Application number: 2025/92415	
What is the application for?:	Erection of single storey rear extension and rear dormer with alterations to roof
Address of the site or building:	24, Church Lane, Gomersal, Cleckheaton, BD19 4QQ
Postcode:	BD19 4QQ

Proposed Rear Elevation
Scale: 1 : 100

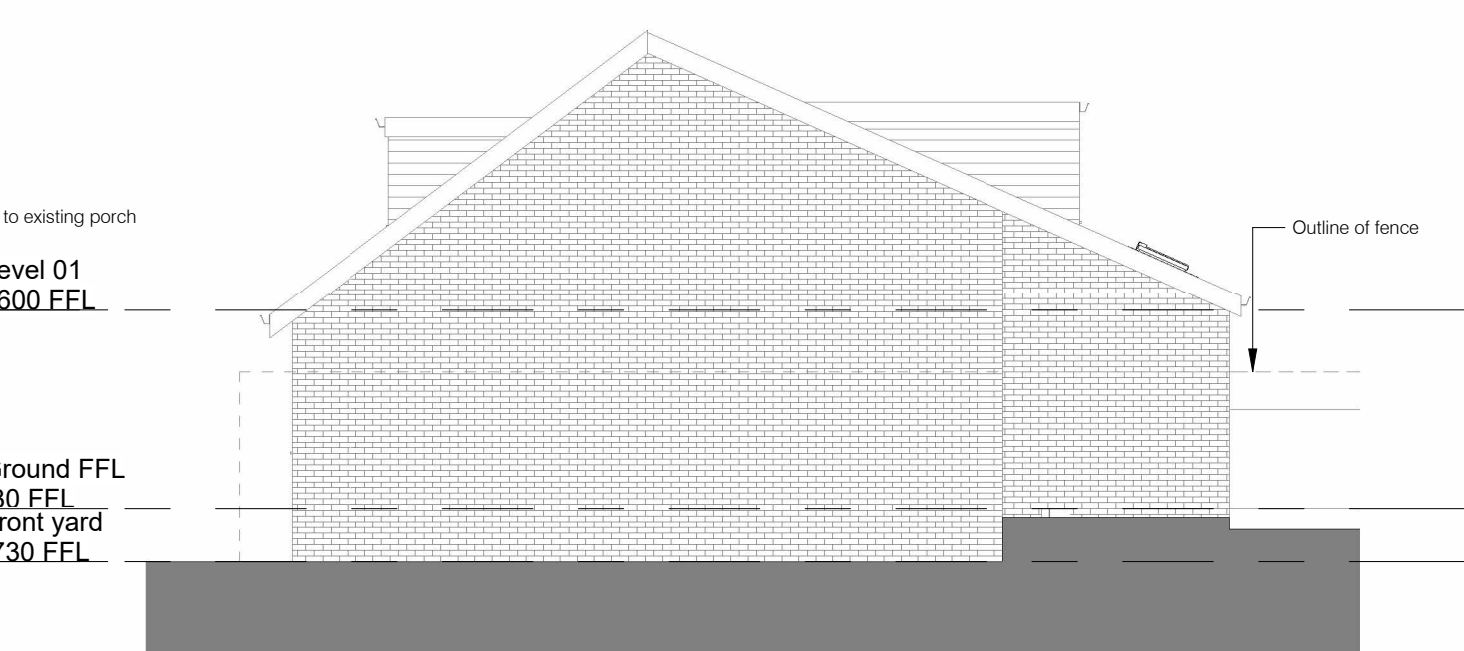
Type of comment: An objection	
Do you wish your comments to be published on the website anonymously?	Yes
I wish to object only re the rear dormer on this property. The plans show 2 windows which will directly overlook the front of my property and that of the property opposite. The house is on Church Lane but this impacts onto Craven drive and Close. The dormer will look straight at into my front windows and garden as it has an unobstructed view.
